Appendix 2 – ECC response to REP4-298

Applicant's Comments on any Further Information or Submission Received by Deadline 3, Doc 8.4.9 (REP4-298)

Appendix 3 – ECC response to REP4-299

Response to Applicant’s Comments on Responses to ExQ1, Doc 8.4.10 (REP4-299)

THE NATIONAL GRID
(NORWICH TO TILBURY) ORDER
INDICATIVE HIGHWAY MITIGATION PLANS
SECTION E (SHEET 7 OF 7,
BRAINTREE DISTRICT COUNCIL)

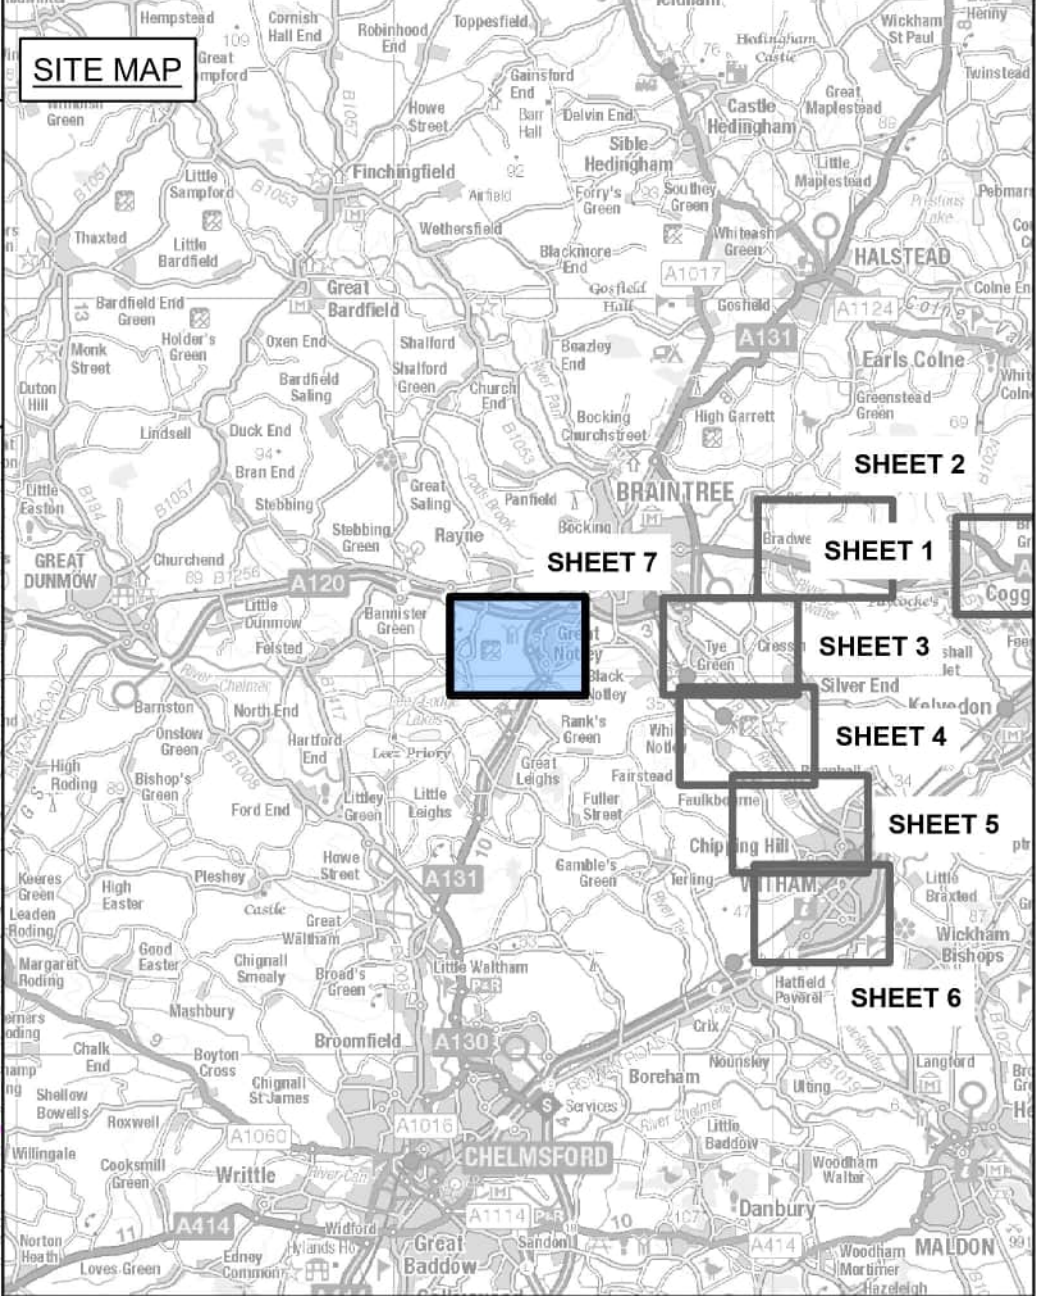
construction and will update 7.3 Outline Construction Traffic Management Plan [Revision C] accordingly	
11	P39, 5.2, 4.5.89	<p>The proposed removal of street furniture on Spa Road at Constraint E7, as shown on Sheets 5 and 6, Section E of 7.3 Outline Construction Traffic Management Plan [Revision C], Appendix C Indicative Highway Mitigation Plans, submitted at Deadline 4, is intended to facilitate the movement of Abnormal Indivisible Load (AIL) vehicles to site, rather than the movement of general HGV construction traffic.</p> <p>The Applicant notes that the mitigation plans included within 7.3 Outline Construction Traffic Management Plan [Revision C] are indicative only. They have been prepared to demonstrate the type and extent of potential mitigation that may be required. These matters will be determined by the Main Works Contractor during the development of the detailed design. Given this, the Applicant considers that it would not be appropriate or proportionate to submit detailed mitigation plans or include commitments within 7.3 Outline Construction Traffic Management Plan [Revision C] at this stage</p>	<p>The drawing referenced by the Applicant shows a constraint at this location that requires temporary works in the form of “<i>modifications to existing highway features, including vegetation removal/cut back where required.</i>” The Applicant has suggested this is in relation to facilitating AILs.</p> <p>The point raised by ECC is related to whether HGV movements can be facilitated on Spa Road (rather than focussing on AILs). ECC requested tracking analysis of HGVs to understand whether the existing highway facilities are suitable for the uplift in HGV movements and if mitigation was required then a concept design produced by the Applicant. This concept design would then be discussed in more detail with the Contractor through the detailed design process. The reason this has been requested is that ECC has concerns with the uplift of HGVs regularly using this route in relation to maintenance at this location which in turn could lead to road safety issues for pedestrians. For example, an increase in vehicles overrunning the kerb which could lead to kerb or footway damage impacting on pedestrian users.</p>
